**KIRKLEES COUNCIL
TOWN AND COUNTRY PLANNING ACT 1990
HIGHWAYS DEVELOPMENT MANAGEMENT**

PLANNING REF 2018/62/94203/W0/NH
CATEGORY Minor

PROPOSAL DEMOLITION OF EXISTING
KENNELS BUILDINGS AND
ERECTION OF TWO DWELLINGS

LOCATION HOLMFIRTH BOARDING KENNELS,
WOOD COTTAGE,
GREENFIELD ROAD,
HOLMFIRTH,
HD9 3XF

SWEEP PATH ANALYSIS
FIRE APPLIANCE

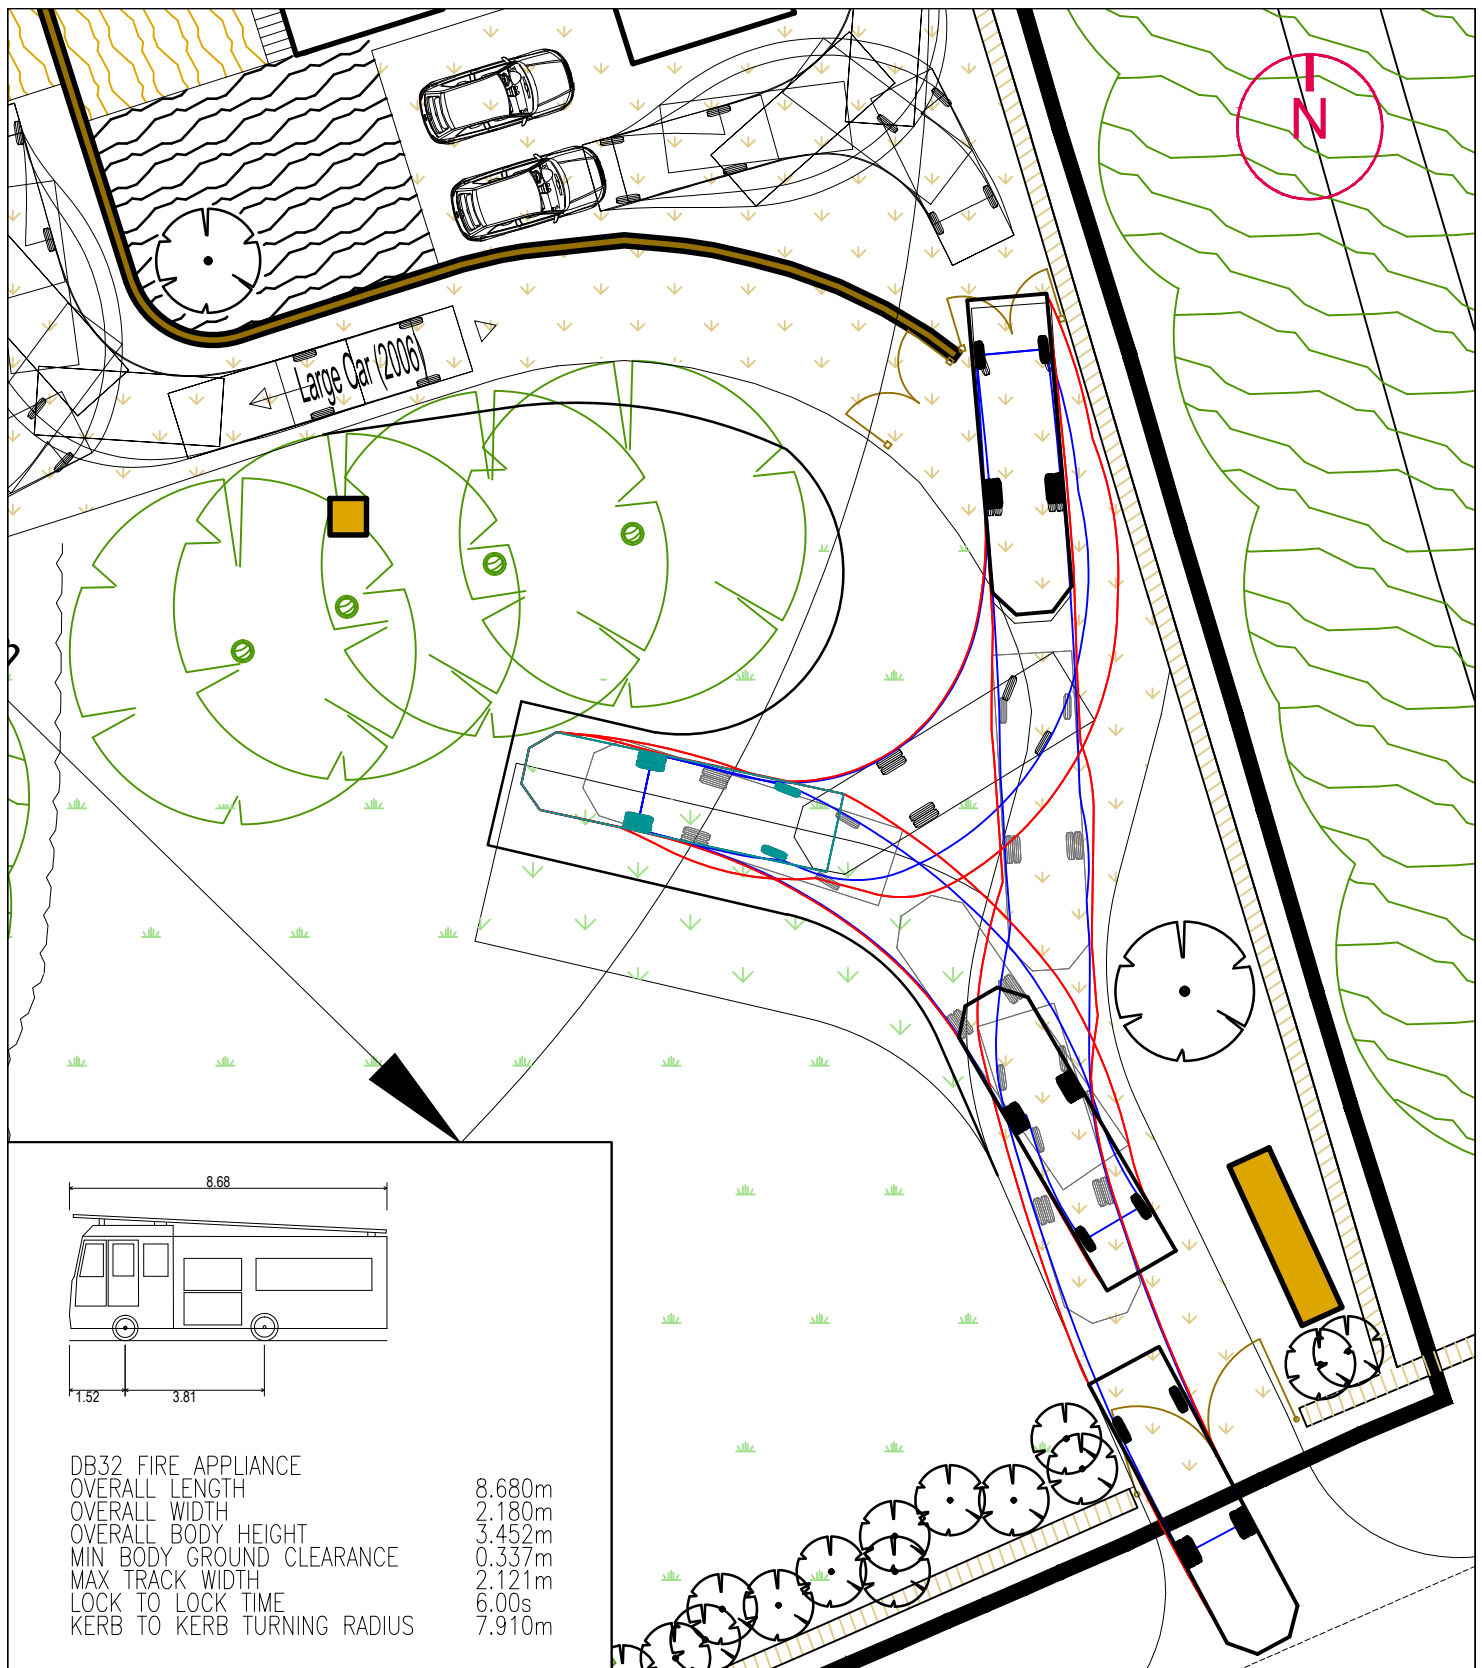
An appropriate turning area for a fire tender to enter and exit the site in forward gear should be incorporated into the proposals as the site is further than 45m from the main road which is classified, if this cannot be achieved a fire hose inlet (dry riser) or sprinkler system arrangement should be investigated.

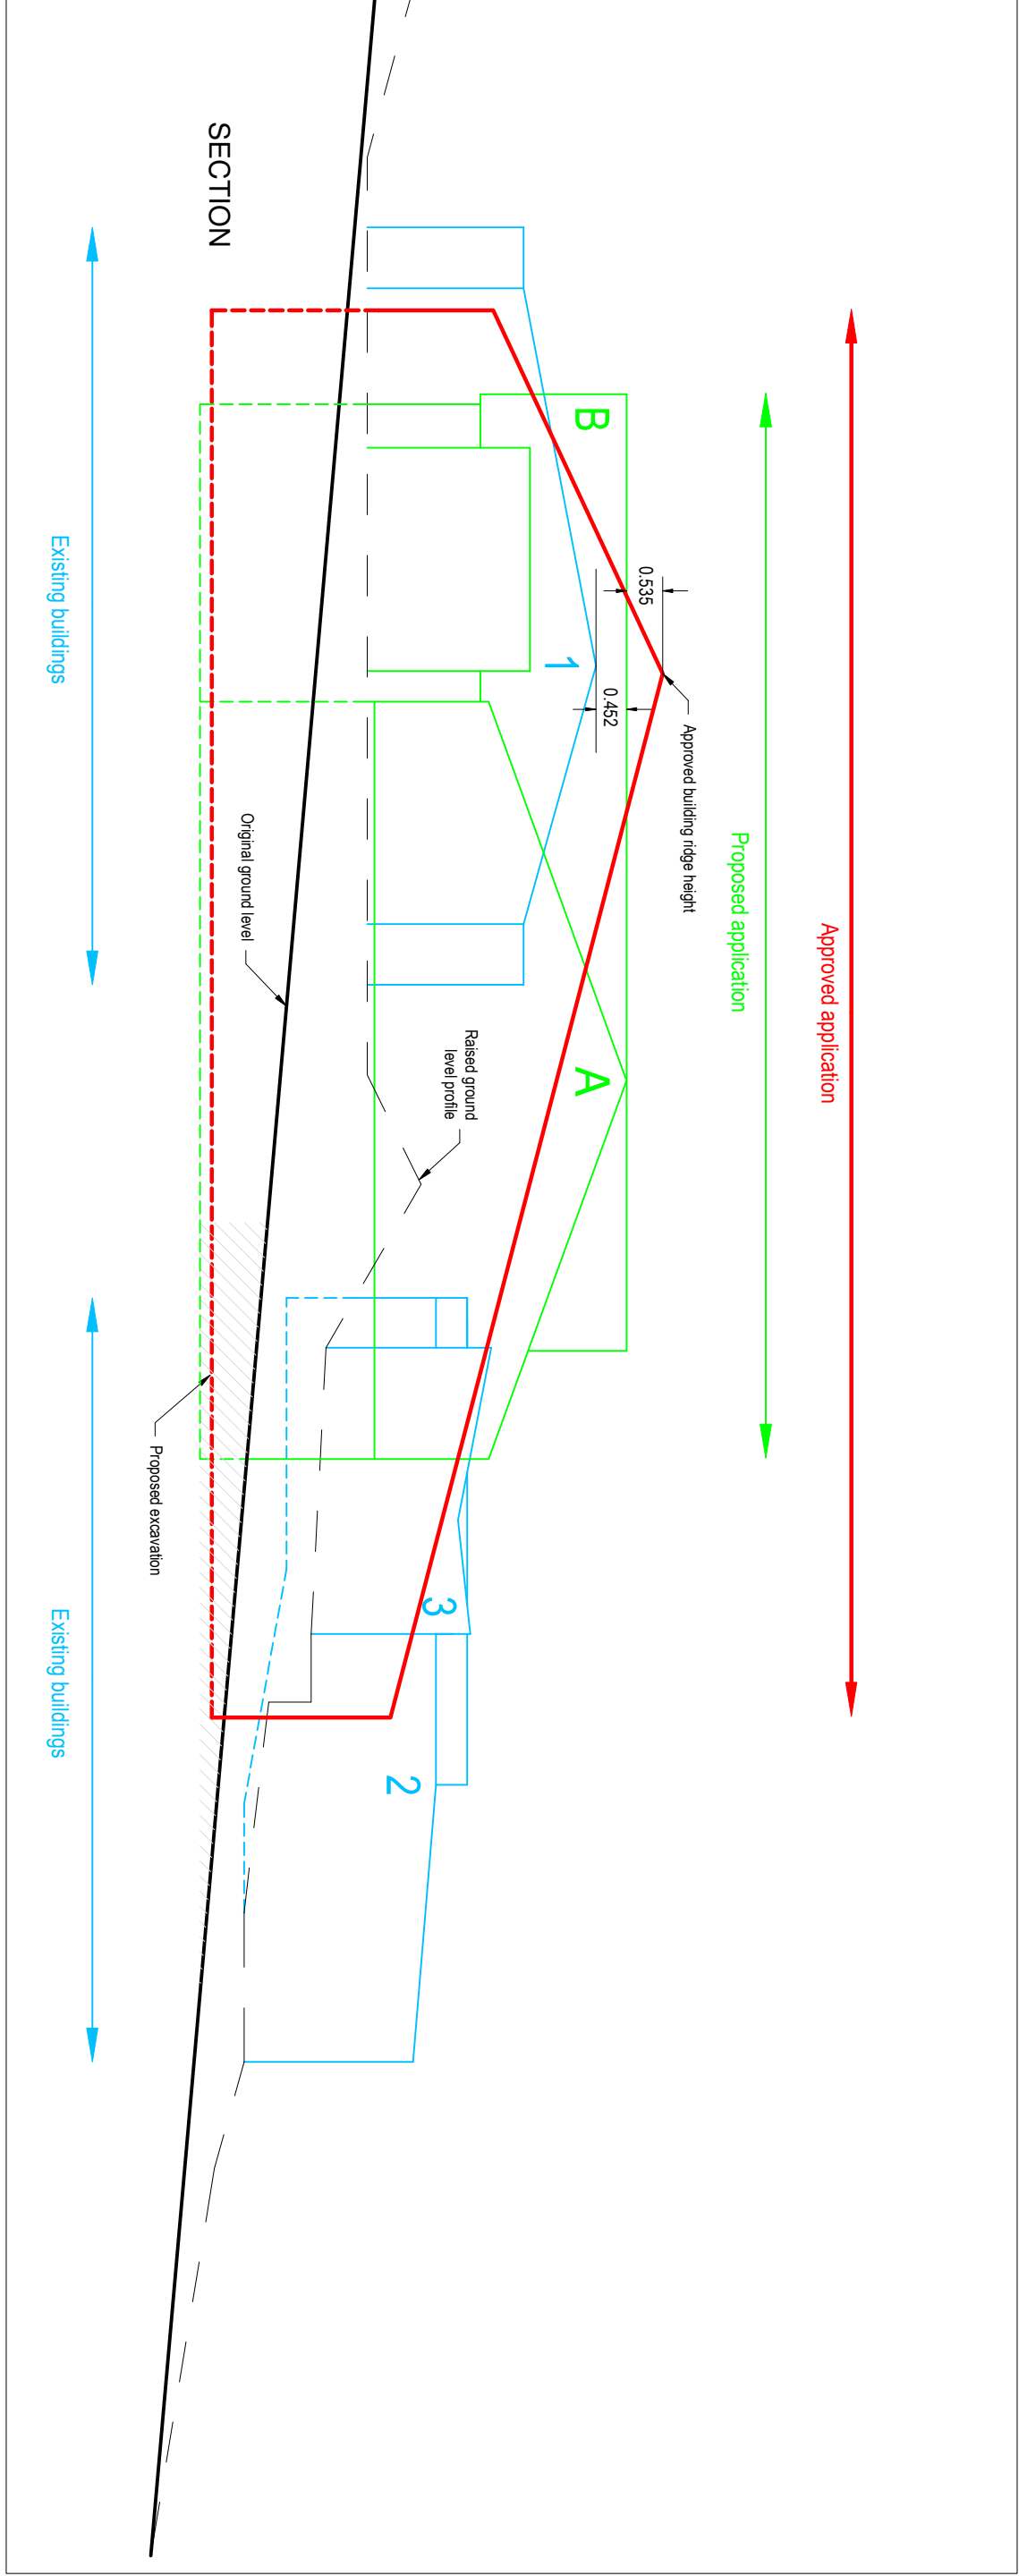
The proposed bin collection point is considered acceptable although if this is where the bins are to be kept permanently does exceed the carry distance for residents to transfer waste.

The proposed shared driveway should be a minimum width of 4.5m for at least the first 5 metres for more than one dwelling to accommodate two way vehicle movements and remove the need for vehicles to reverse onto the highway.

The proposed gates adjacent to the highway should be set back at least 6m to remove the need for vehicles to wait on the highway.
